Our Ref: EP/58/11/

Replace 3 no. existing estate entrance gates (this application fall within the parish of Rustington)

North end of The Ridings & Angmering Lane & east end of Tamarisk Way East Preston

The Planning Committee of this council considered this Application at its meeting on Monday, 27th June.

3

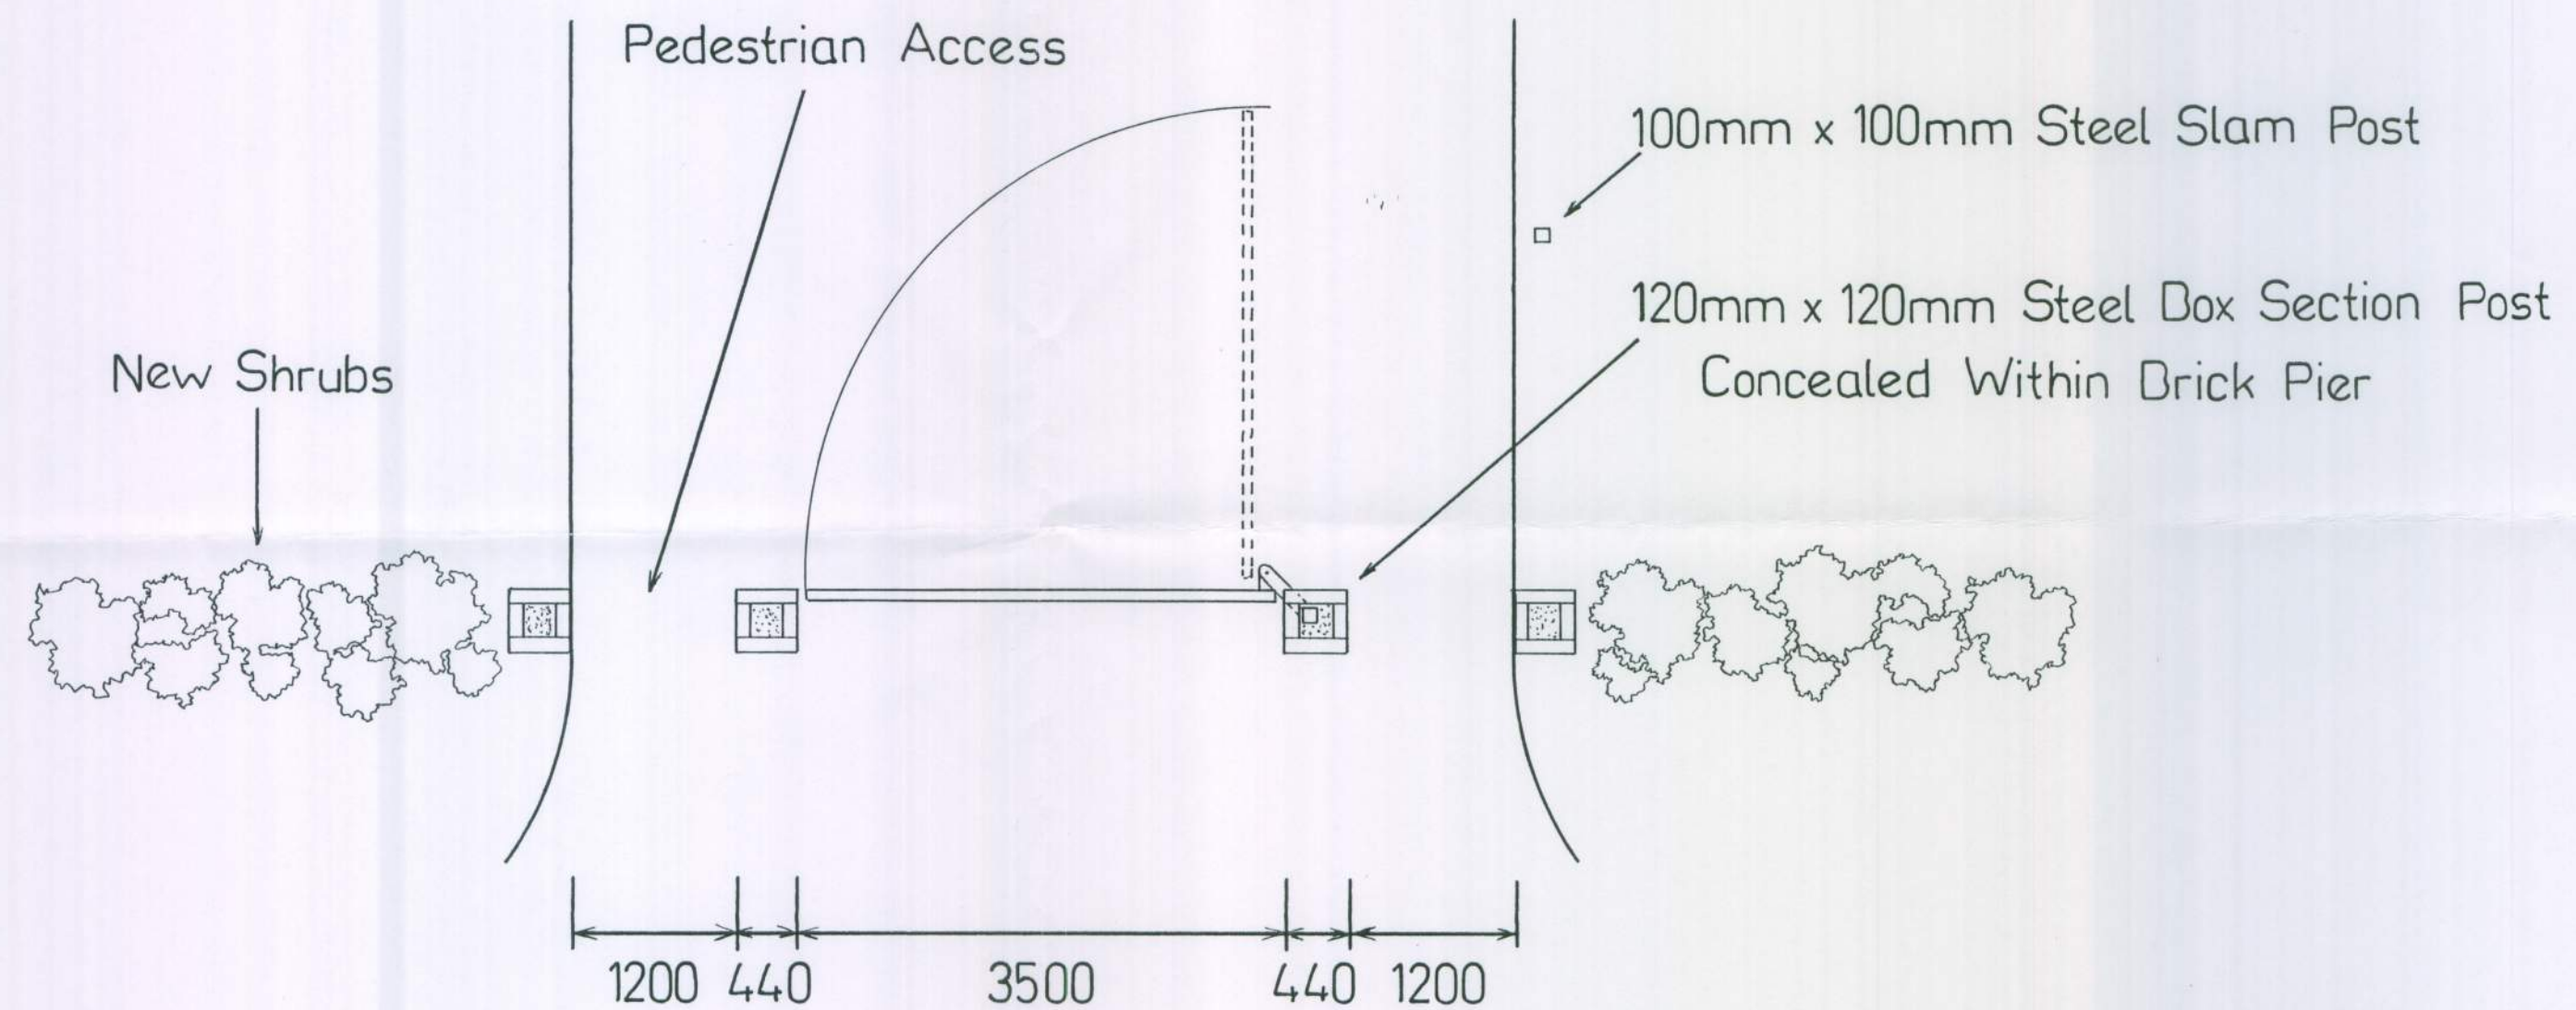
*It agreed that it would object to this Application on the following grounds:
The Committee believes that the design of the gates is out of keeping with the rural ambiance of the estate, much of the development having occurred before 1939. The design is considered to be challenging and unimaginative.*

The proposal would be out of keeping with the prevailing character and appearance of the street scene and detrimental to the spatial quality of the general locality. The proposal is thereby in conflict with Local Development Plan Policies.
